Highways England Planning Response (HEPR 16-01)

Formal Recommendation to an Application for Planning Permission

Council's Reference: 2020/91889

Referring to the planning application referenced above, dated 29th June 2020 for the discharge condition 20 on previous permission 2016/92298 for outline application for re-development of former waste water treatment works following demolition of existing structures to provide employment uses (use classes B1(c), B2 and B8) at Former North Bierley Waste Water Treatment Works, Oakenshaw, BD12 7ET, notice is hereby given that Highways England's formal recommendation is that we:

No. 60221630					Rev: 5

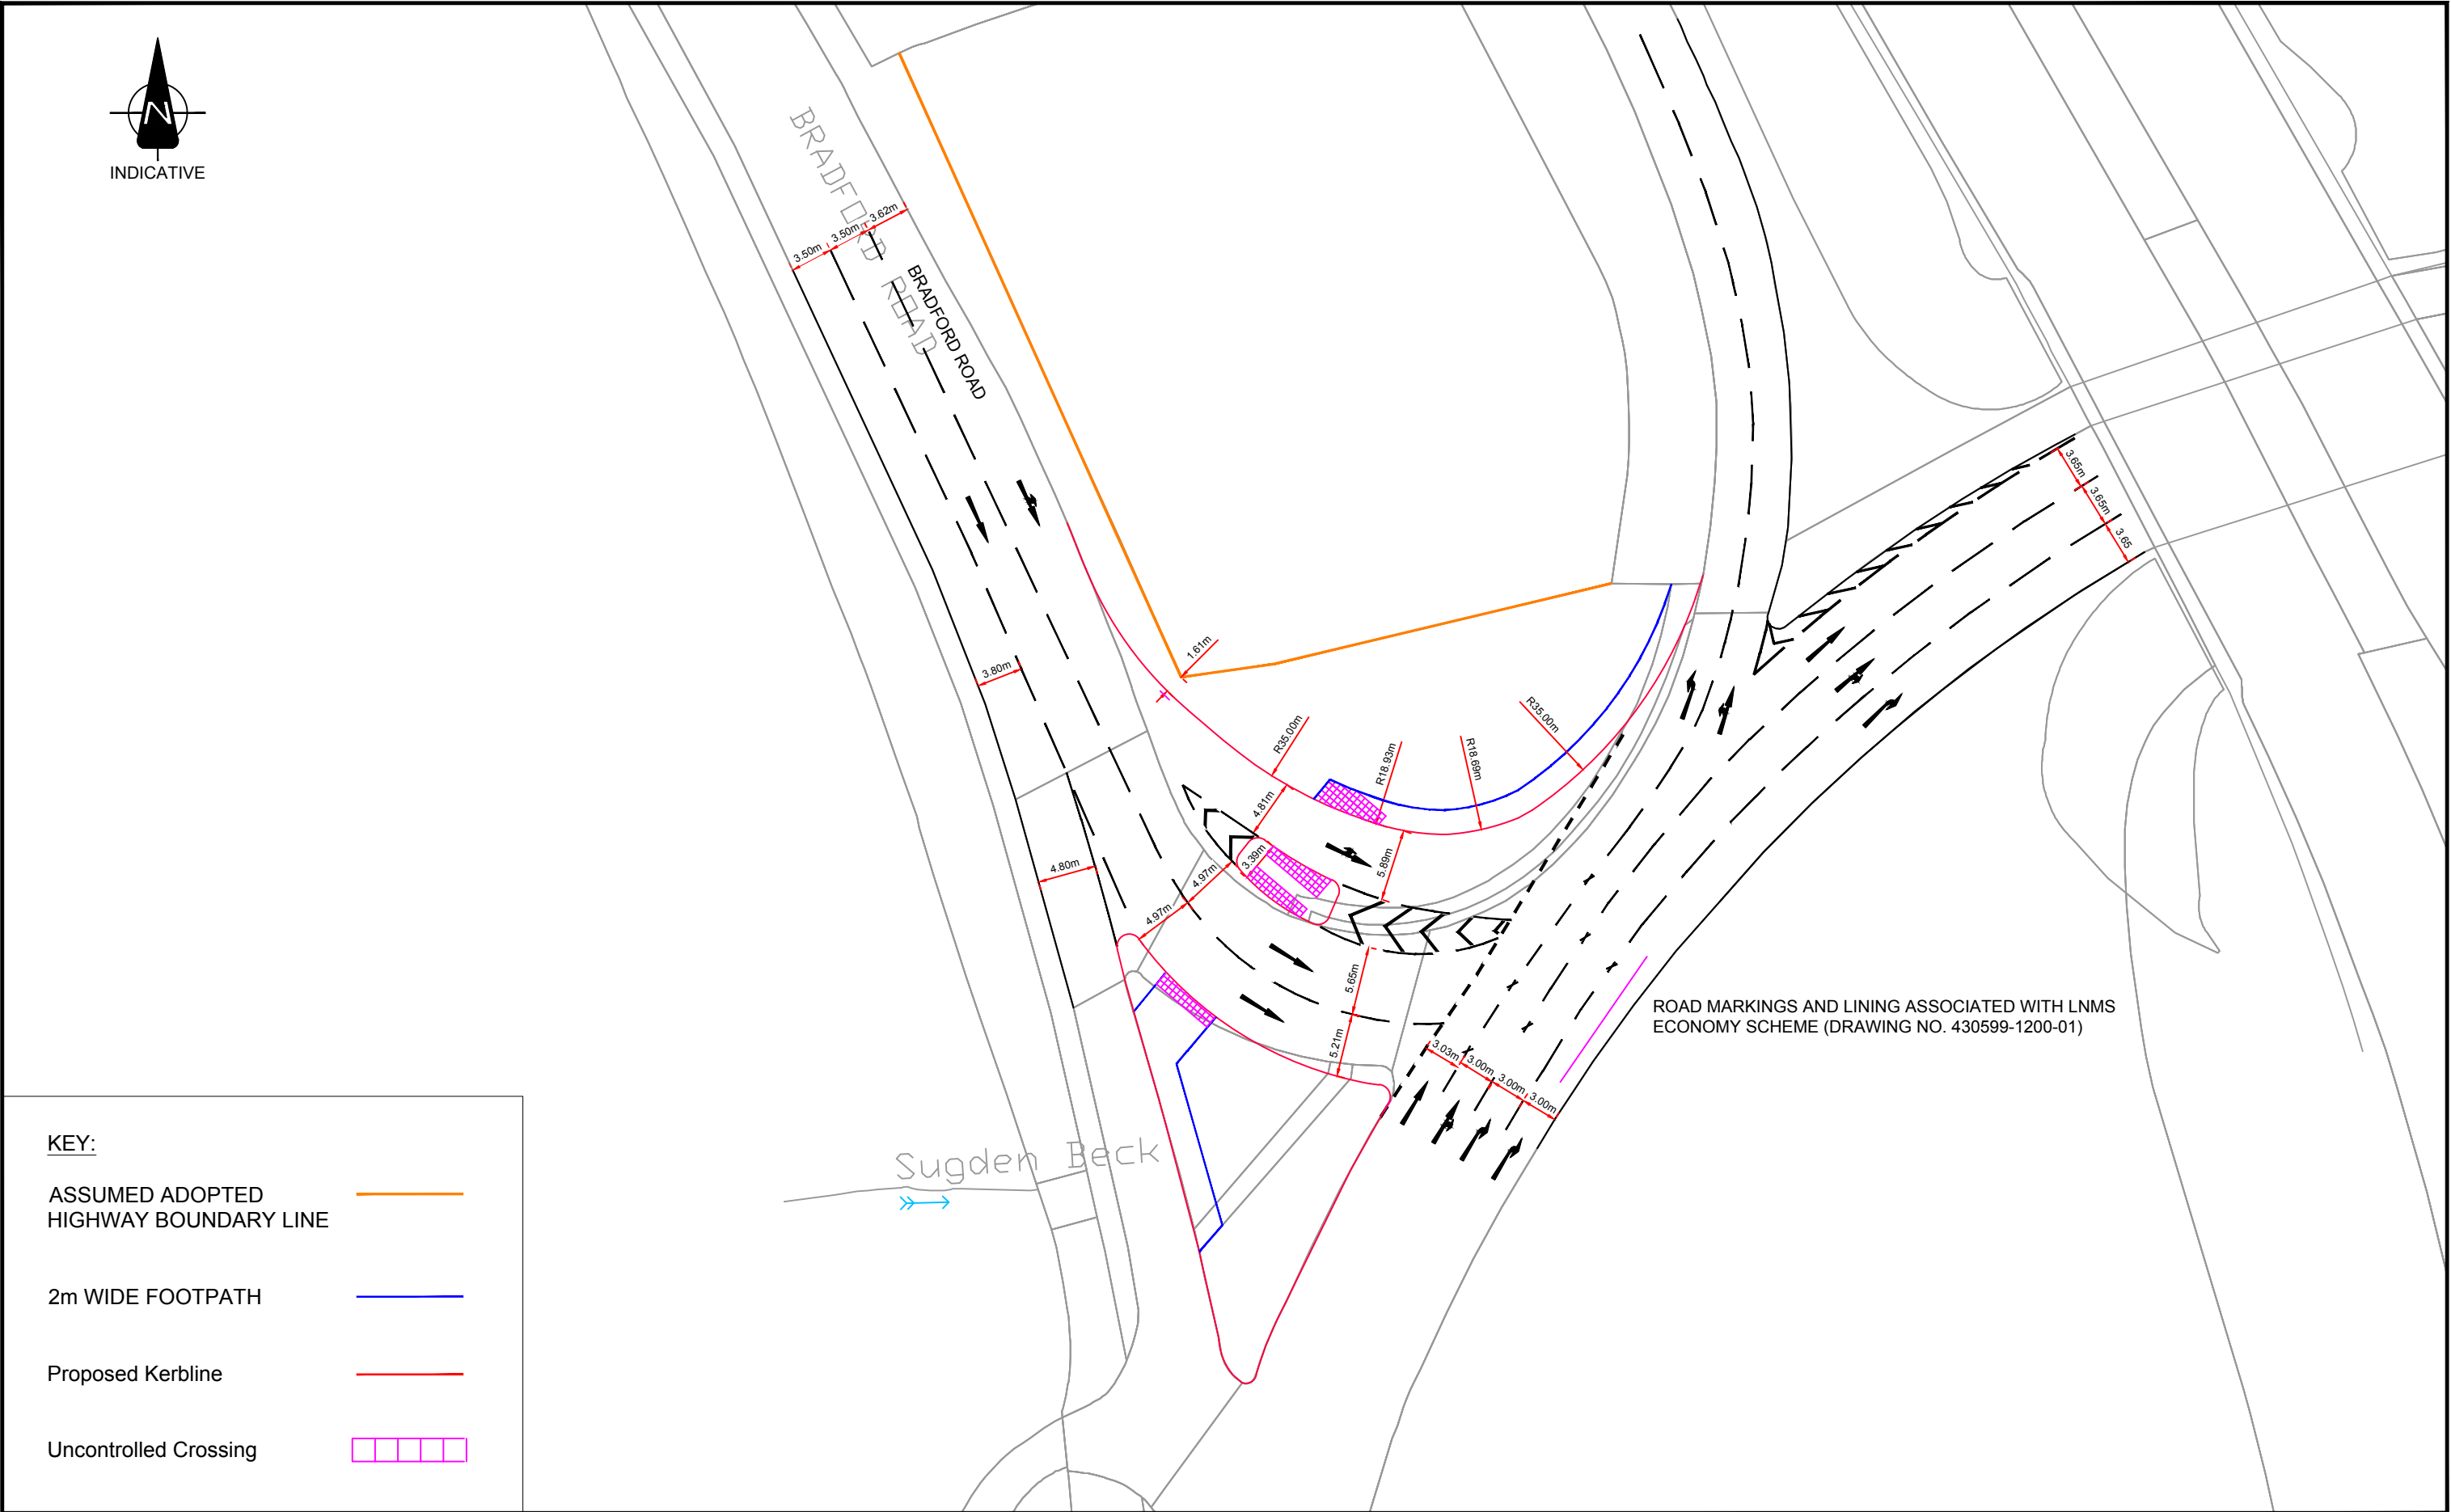
Whilst Highways England accepted the principle of the proposed works outlined in drawing 60221630 Rev 5 we have yet agree the detailed design for the improvement scheme which must also be subject to a Stage 2 Road Safety Audit before we can formally agree that condition 20 being discharged.
